Harnett County

Permit Number: BCOM2605-0006

Description: **Beacon Rescue Mission Program/Retail Store**

LIST OF REVIEWS

STUDY - FLOOR PLAN

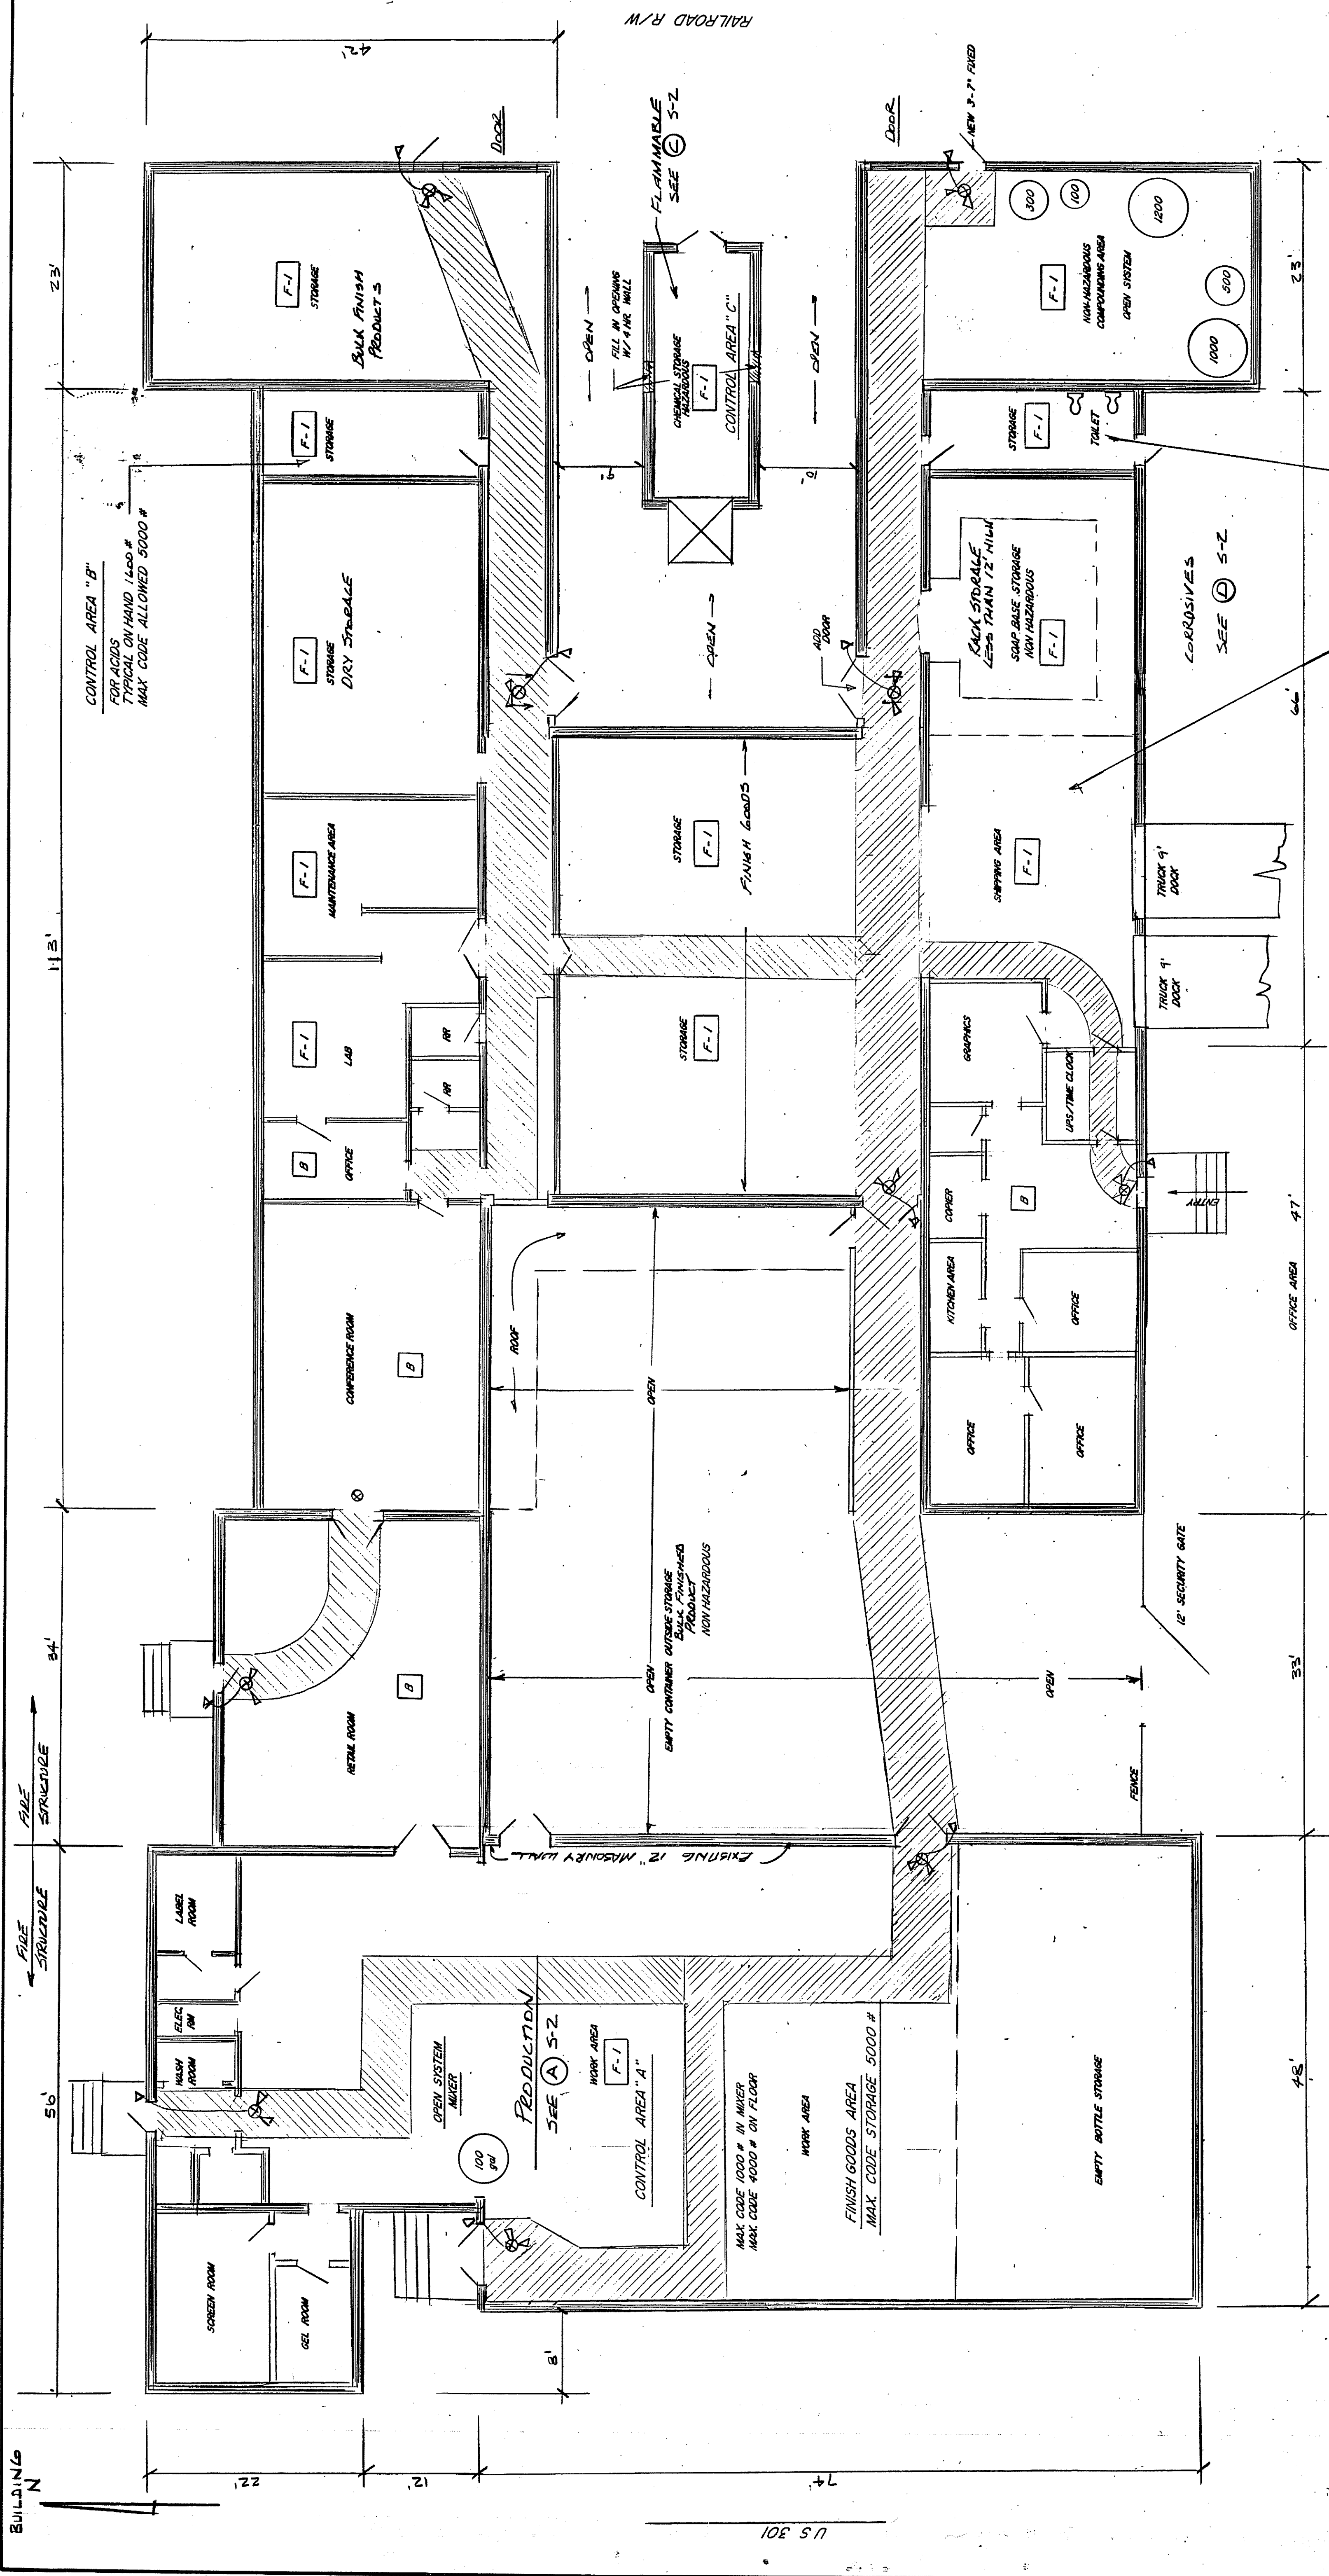
SENT DATE	RETURNED DATE	DUE DATE	TYPE	CONTACT	STATUS	REMARKS
Review Group: 1ST PLAN REVIEW						
6/9/2026			ENVIRONMENTAL	EH Bucket		
Notes:						
6/9/2026	6/23/2026	6/24/2026	FIRE MARSHAL	Roger Sullivan	DISAPPROVED	see notes
Notes:						
- The submitted plan is for the past occupancy (H&H Products), need to submit new plans for the current proposed occupancy.						
6/23/2026	6/25/2026	7/7/2026	PLANNING	Jay Sikes	DISAPPROVED	SITE2606-0003
Notes:						
-more info needed. - SITE2606-0003						
Review Group: AUTO						
5/20/2026	6/23/2026		COMMERCIAL INTAKE	CP Bucket	DISAPPROVED	
Notes:						
5/20/2026			COMMERCIAL BUILDING REVIEW	Building Bucket		
Notes:
